CENTRAL COAST QUARTER - STAGE 1, NORTHERN TOWER

Response to Submissions
Report for SSD-23588910

SH GOSFORD RESIDENTIAL PTY LTD

December 2021

DA103
B

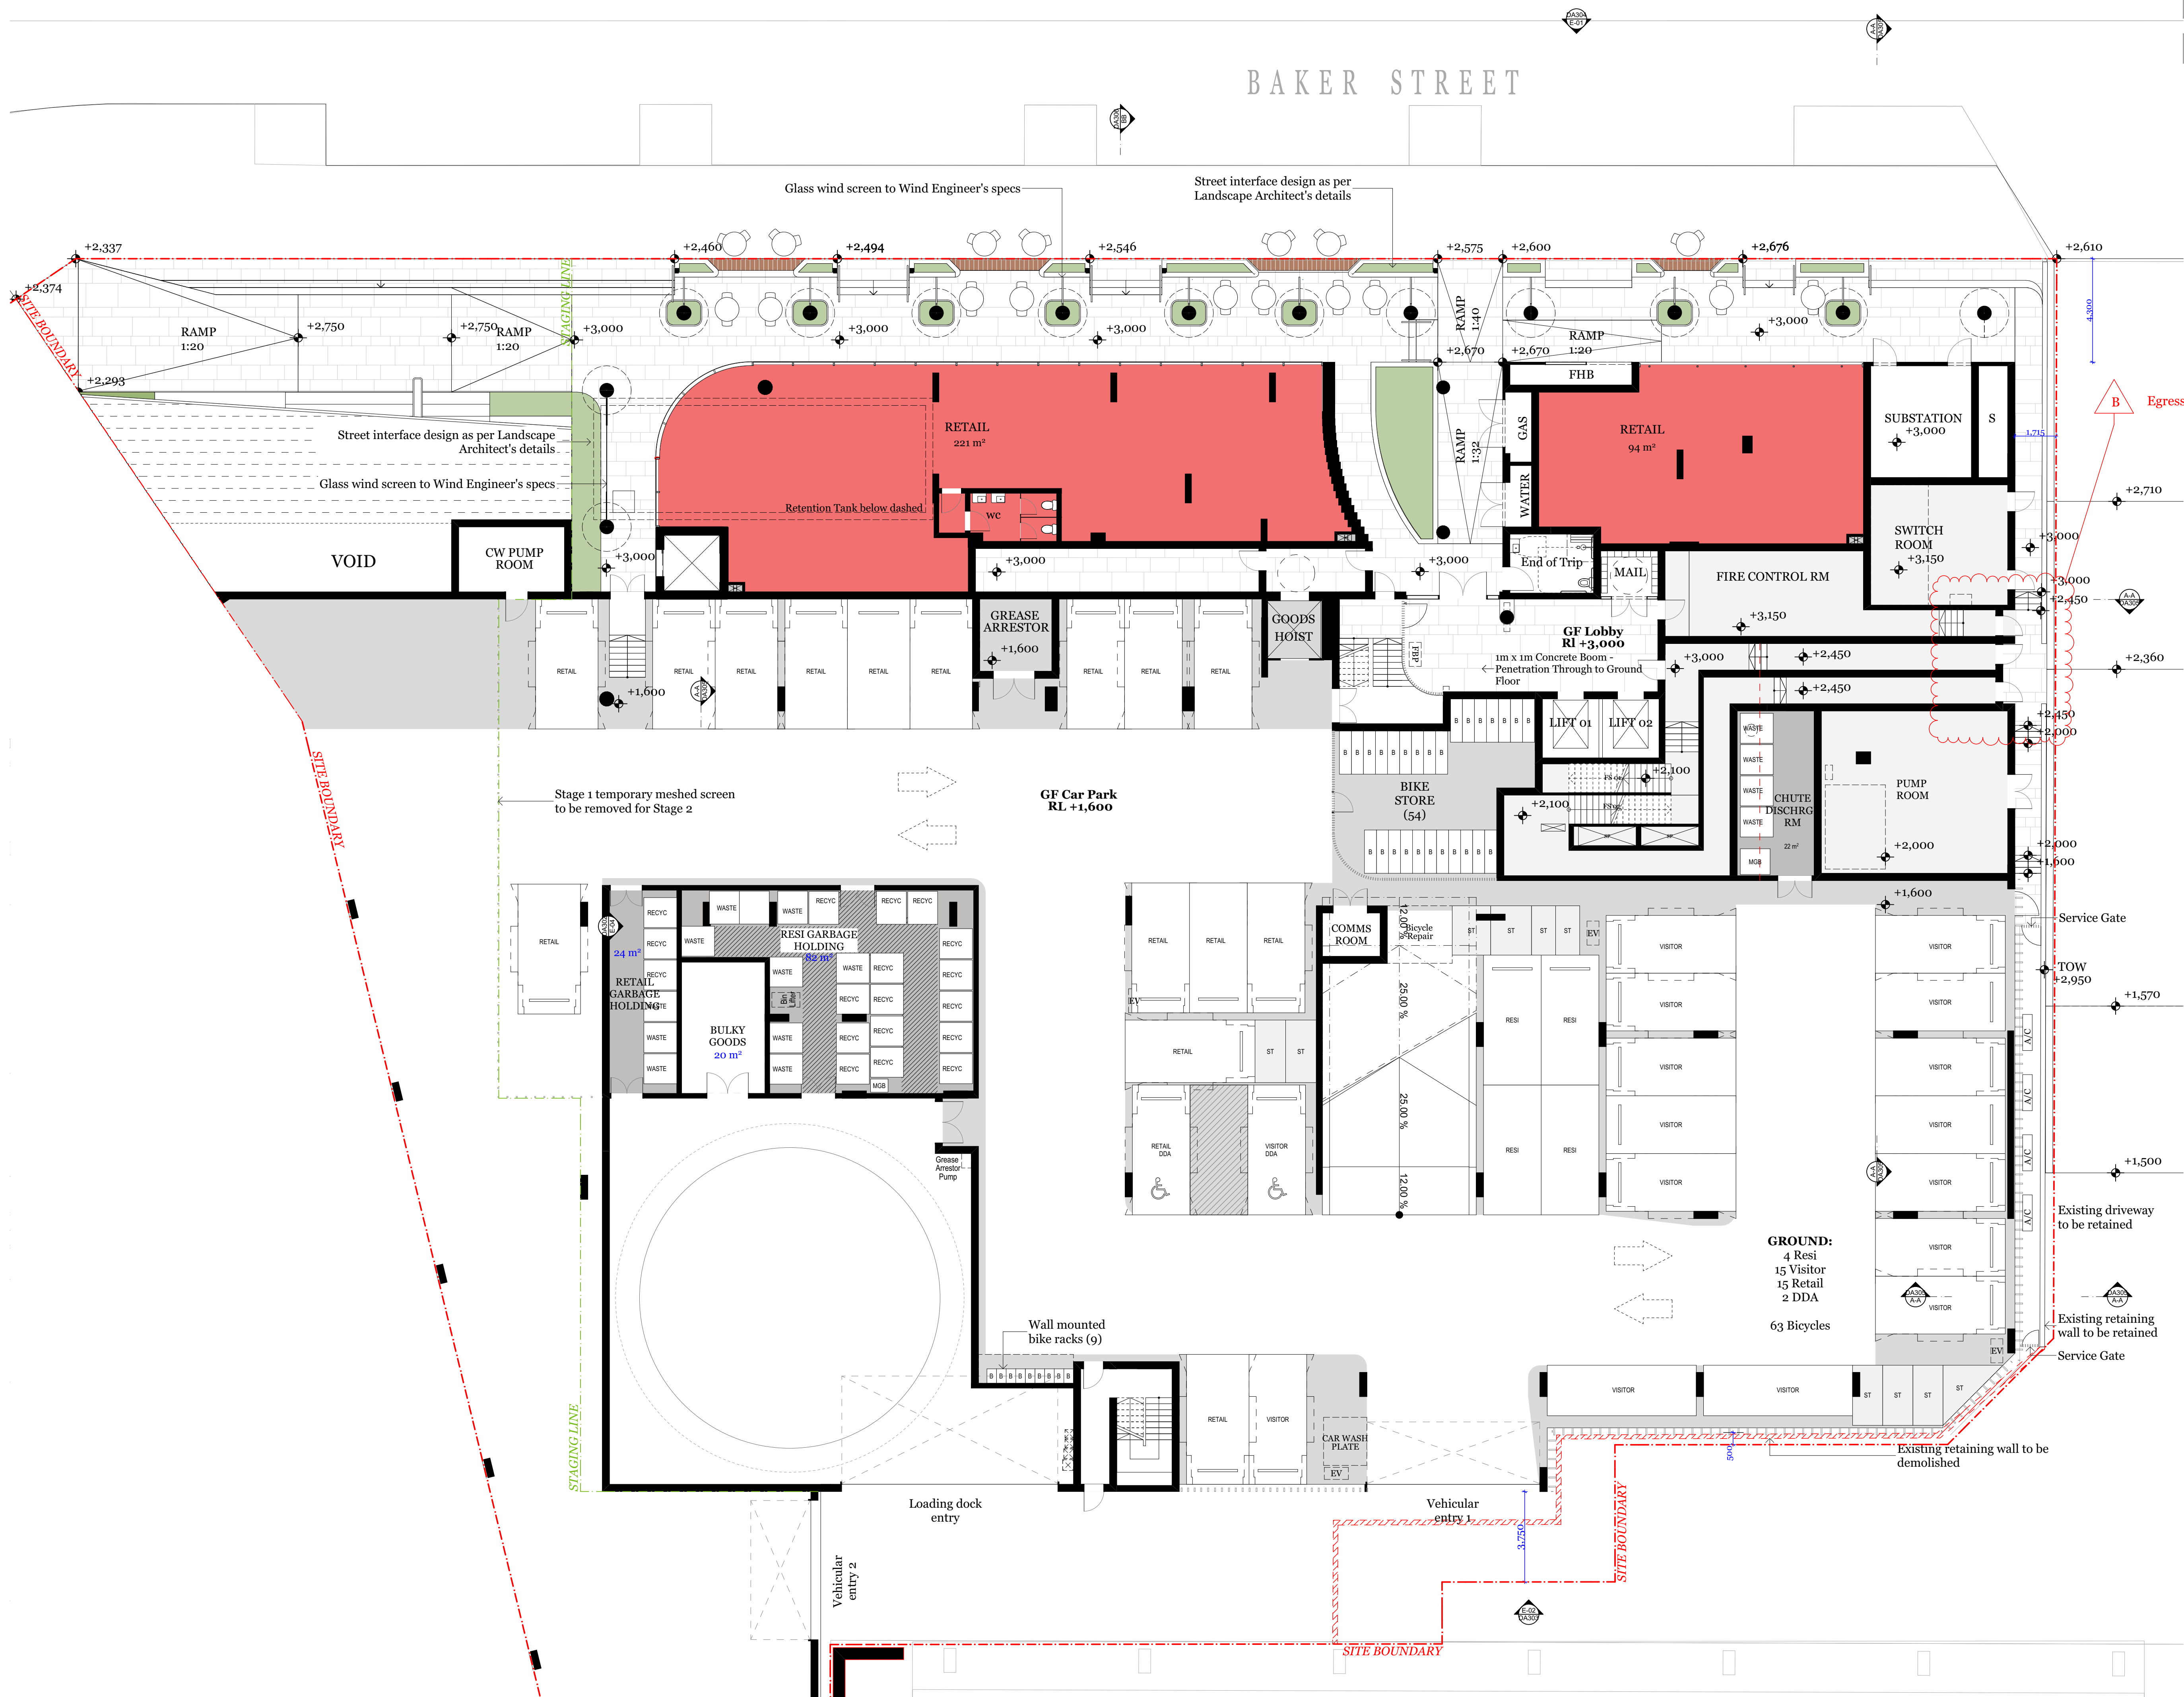
2.	The legal description of the site (Lot/DP) quoted in the EIS (page 27) and annotated on the architectural drawings (DA101A and DA103A) is inconsistent. Also, confirm whether the site is known as 26-32 (to), 26 & 32 Mann Street or another address (noting it only relates to Stage 1 and not the entire Concept Approval site).	The EIS references the legal description of the Concept SSDA site (SSD-10114) because site preparation works are proposed across the whole site. The architectural drawings correctly show the Stage 1 building footprint concentrated in the northern portion of the site. The site address is 26-30 Mann Street, Gosford (as described in the EIS and public exhibition notice).

Drawing Number  
Revision  
DA201  
B

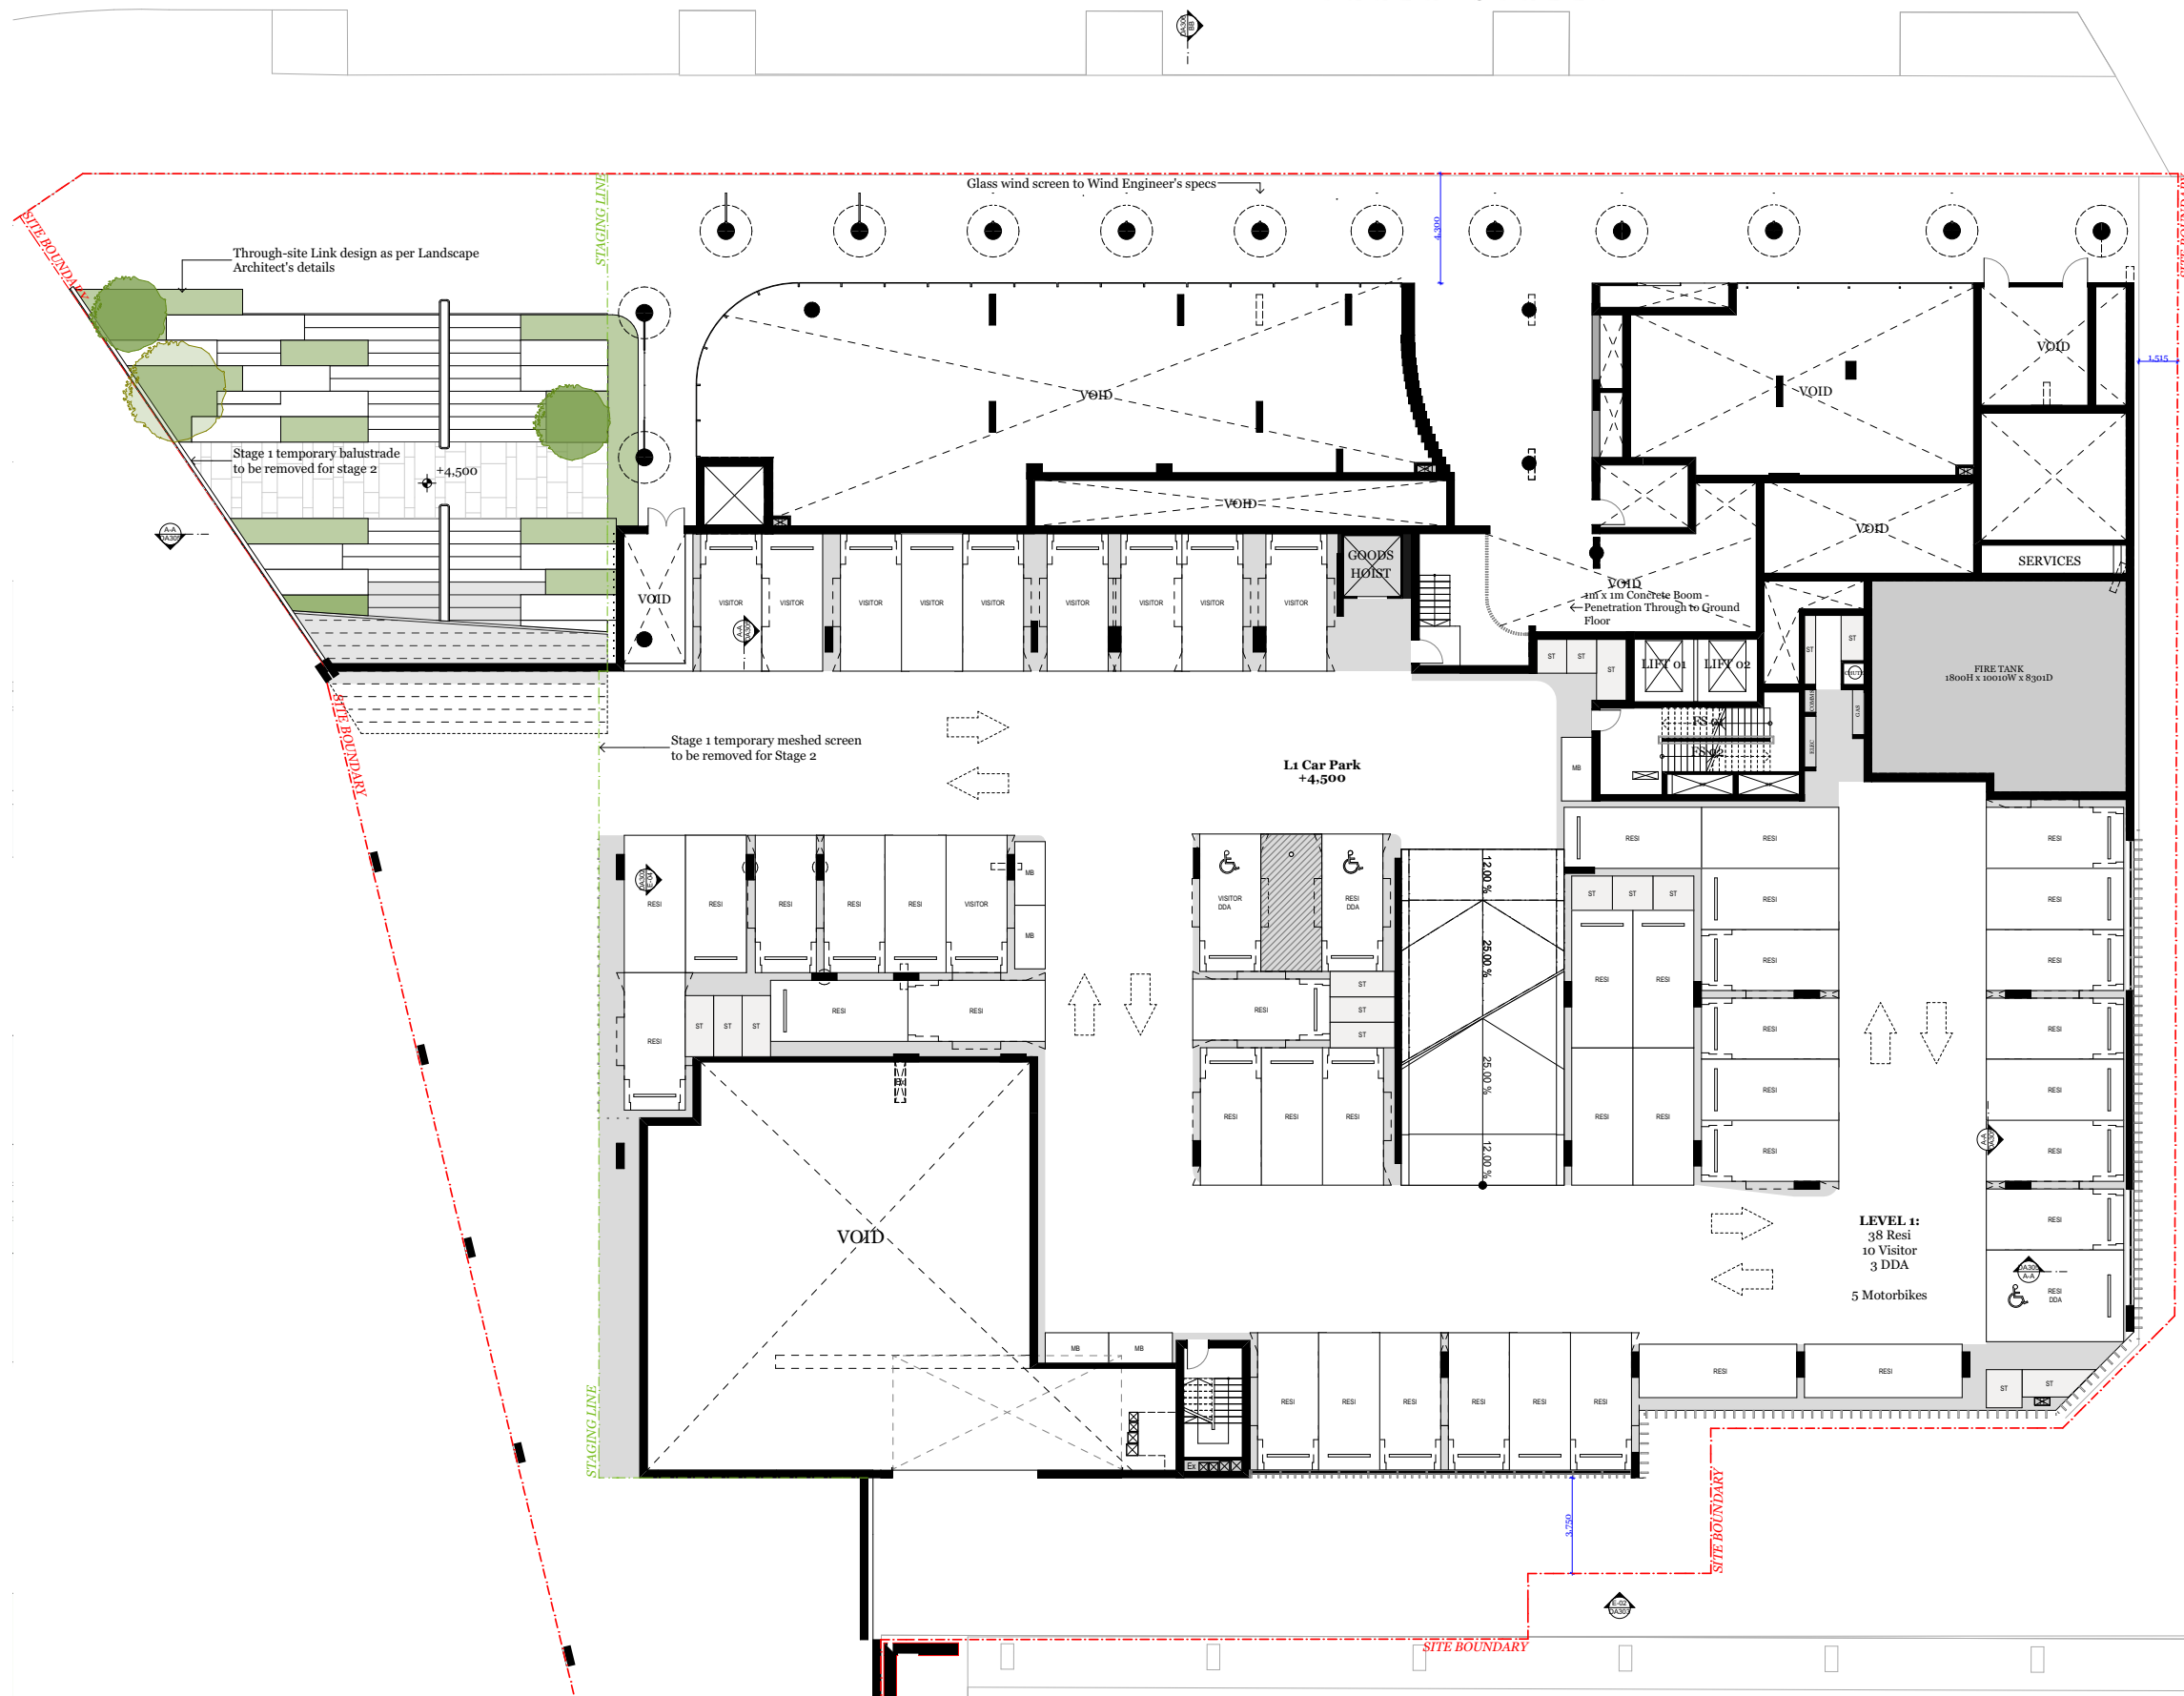
7.	<p>To prevent the creation of an area of concealment/anti-social behaviour, extend the ground floor entrance doors (to the lift lobby and stair core) forward so they are flush with the building northern elevation fronting the adjoining service road.</p>	<p>The fire egress doors have been amended/extended forward as far as permitted in accordance with the BCA and fire safety codes. Refer to DA-201.</p>
